Response to Submissions

UNSW D14 Academic Building Planning Application SSD 9606

Prepared for
Lendlease on behalf of UNSW
12 April 2019

Summary of Significant Design Changes from SSDA to RTS

Status	Project No.	Drawing No.	Revision
PLANNING APPLICATION	18026	ADDA00002	05

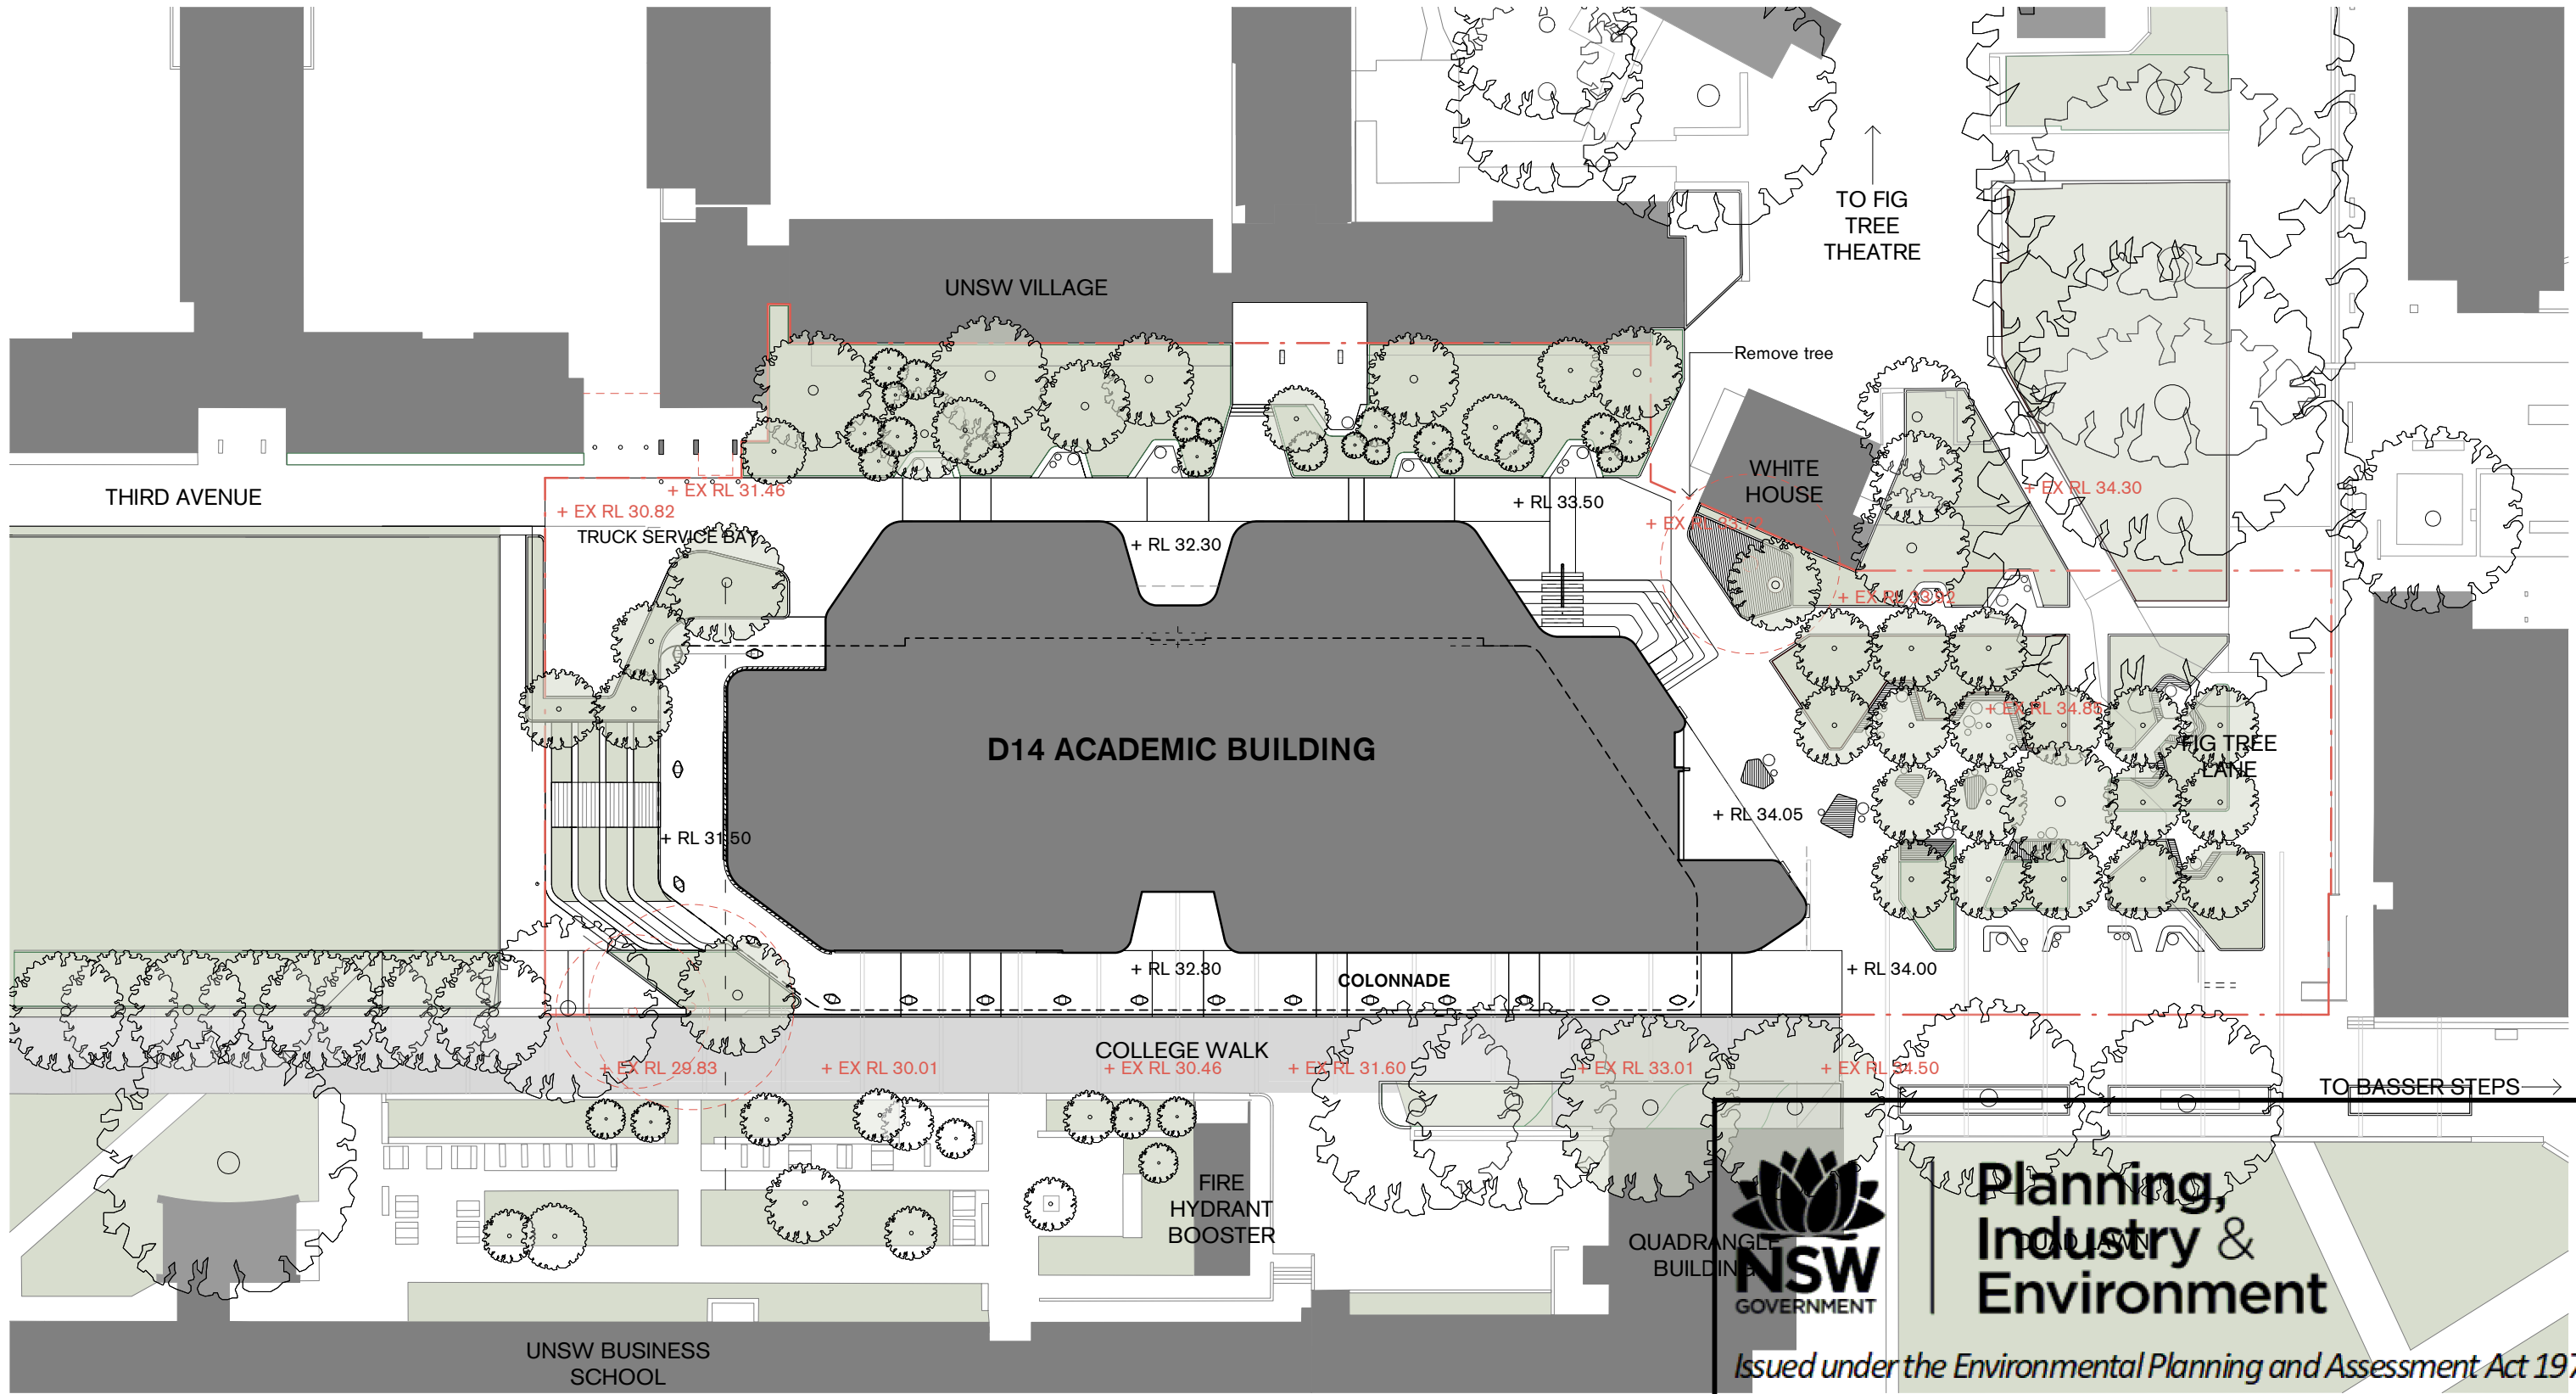
Item	Location	Change	Comment
1	Site	Extension of the project boundary to the north and east. Refer to site plan ADDA00002.	UNSW has committed to extending the project boundary up to UNSW Village to the north and Goldstein Hall to the east. This extension provides scope for a more holistic landscaped solution to integrate D14 with the Old Tote/Fig Tree Theatre Heritage Conservation Area and Quadrangle. This will substantially improve the quality of the landscaped open space and support the masterplan initiative to establish this precinct as an important public room within the campus.
2	Site	Replace existing Black Wattle tree #1119 with a new mature tree to improve the quality of the landscaped area surrounding White House.	Tree #1119 is marked for removal as the specimen is currently at its most mature and will decline in health overtime. To improve the shading over the landscaped area encircling the White House and support future canopy growth, a replacement mature tree is proposed. This will form part of the transition in scale between the single storey D14 terrace and two storey heritage item.
